**From:** Harry Chalk  
**Sent:** 10 June 2025 08:12  
**To:** Planning.Responses  
**Subject:** FW: BR/65/25/PL - New Barn Garage  
**Attachments:** 24004A-P-110-D-Proposed plans.pdf; 24004A-P-013-A-Proposed site plan.pdf; Sub Plan Action Sheet.docx

**Subject:** BR/65/25/PL - New Barn Garage

Dwg No. **24004A-P-013**

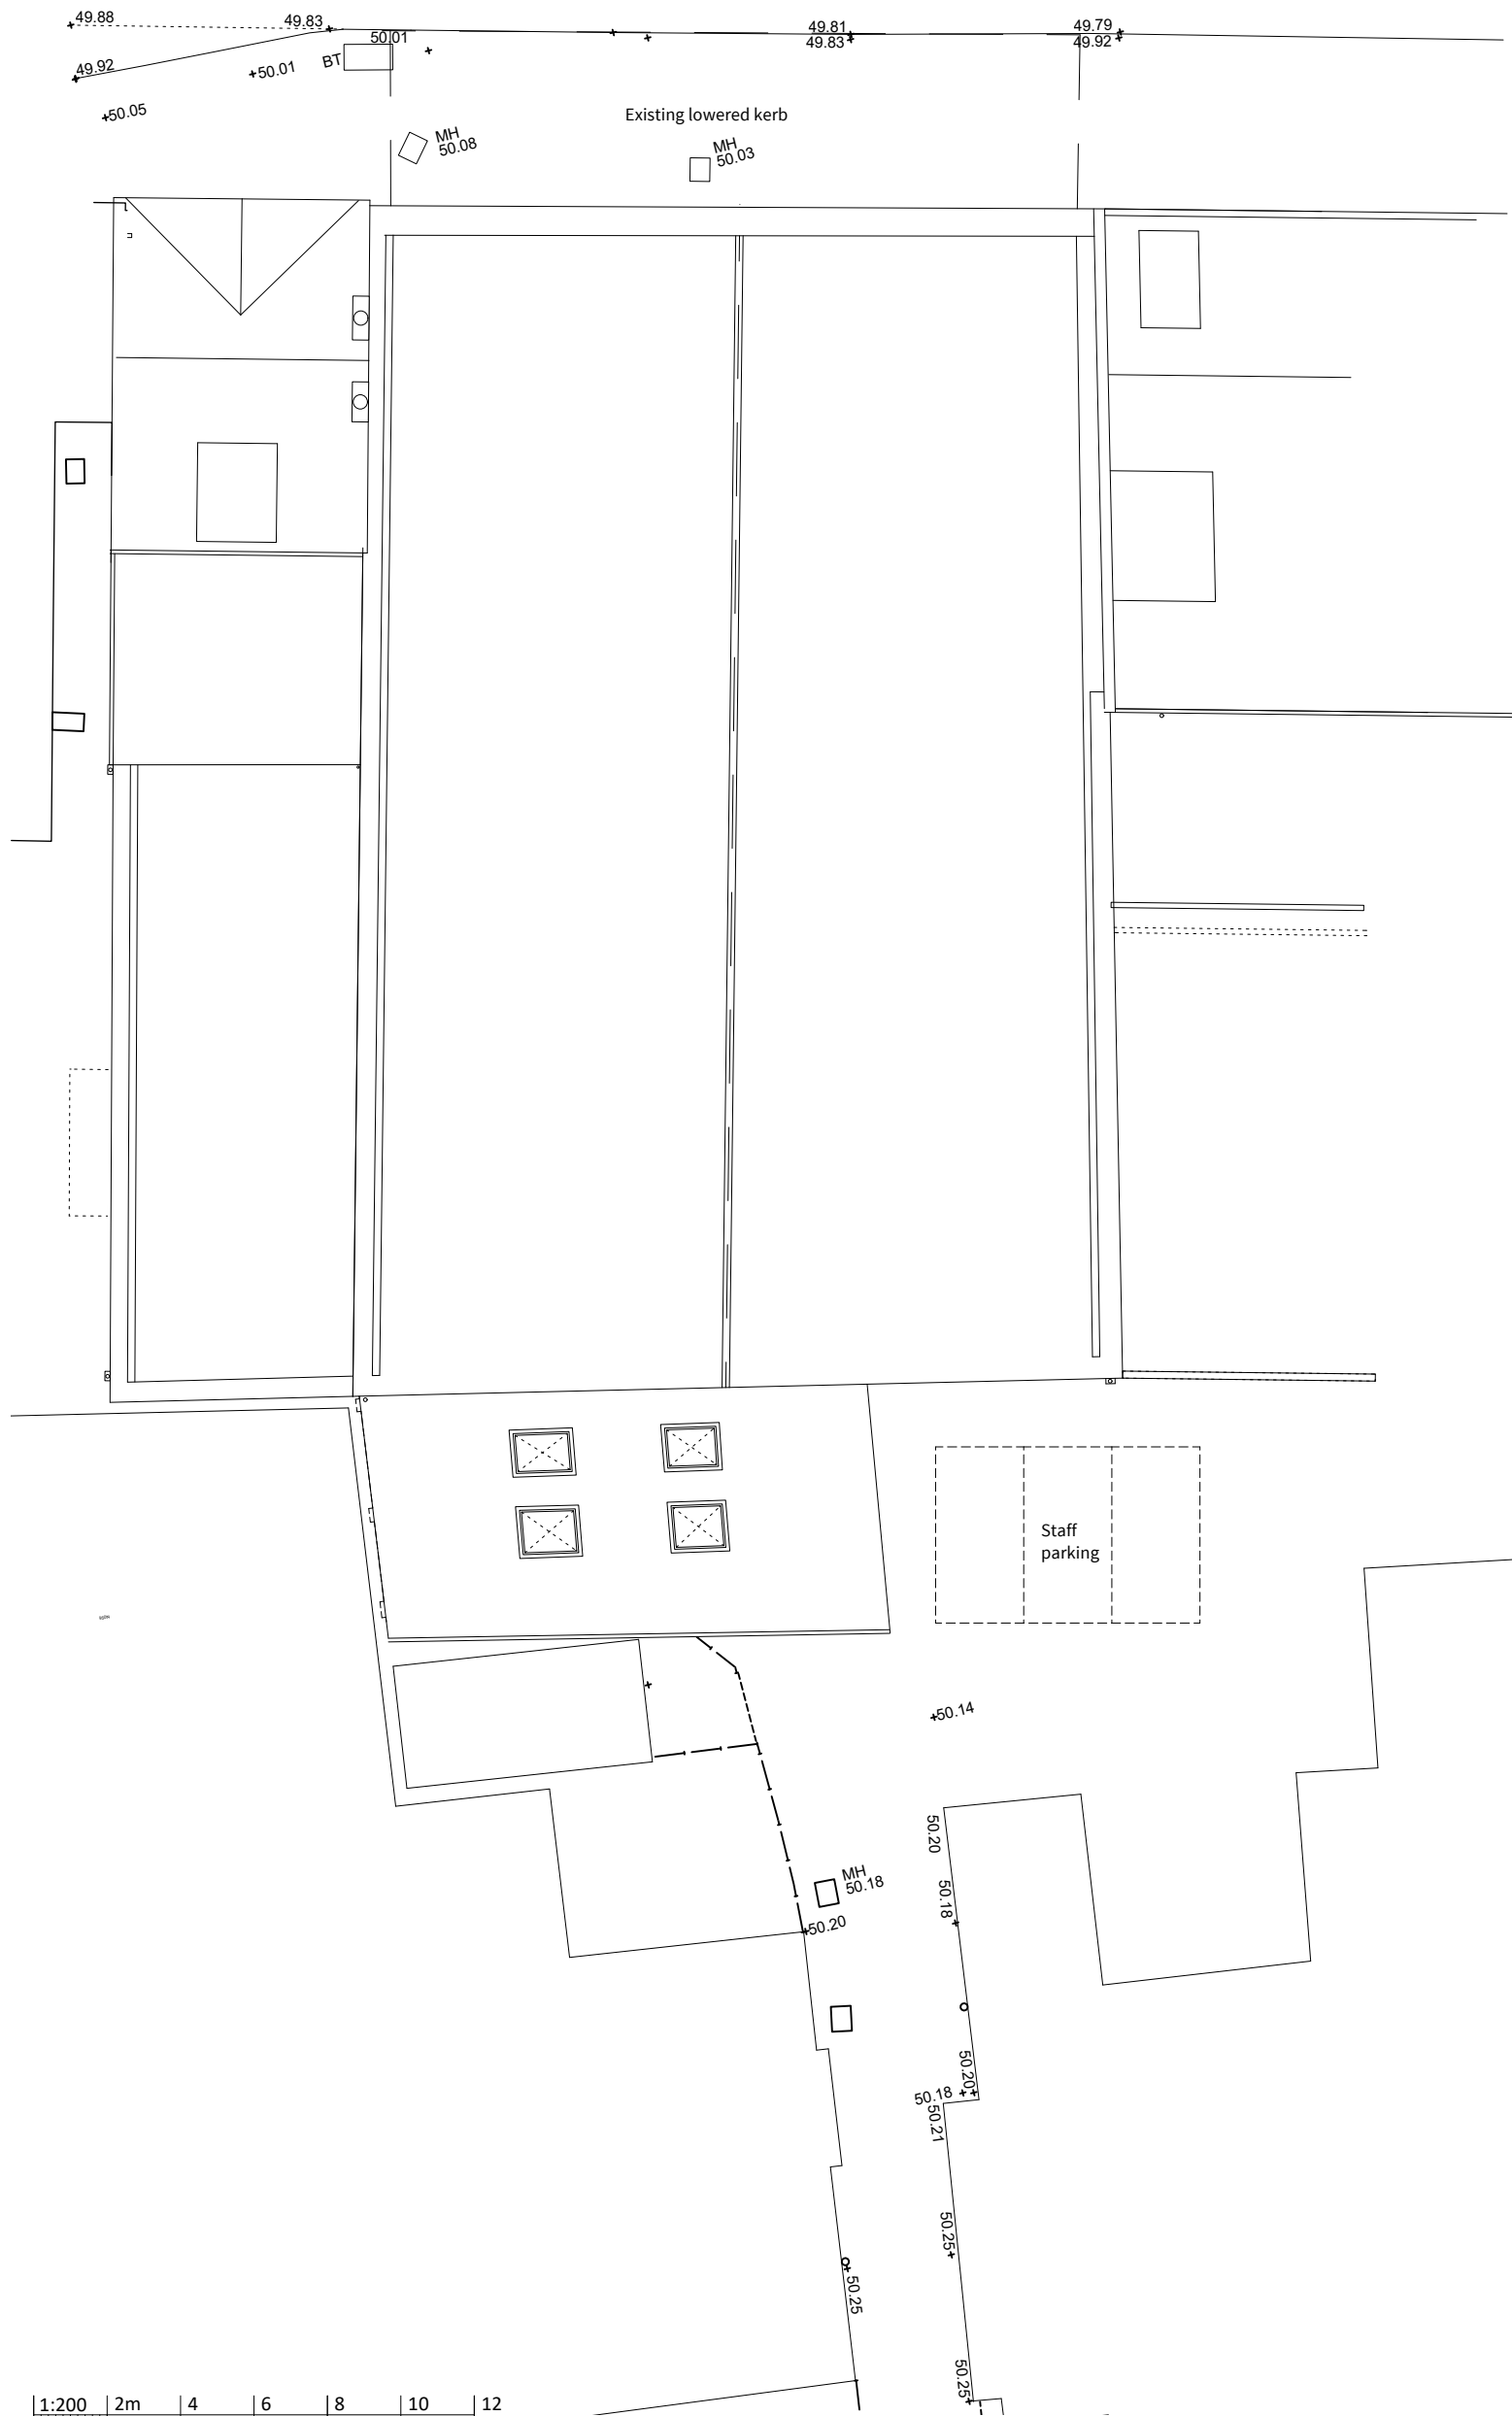
Sorry for the quick follow-up, but could I query the parking provisions laid out to the rear of the site? I note there are three bays, but these seem inconsistently depicted between the site and floor plans, and I am not clear that one of the bays fits within the red edge shown on the location plan. Could you take a look and come back to me by 06/06/25?

Thank you for your email. You are correct the spaces were shown beyond the line. Please find the corrected drawing attached.
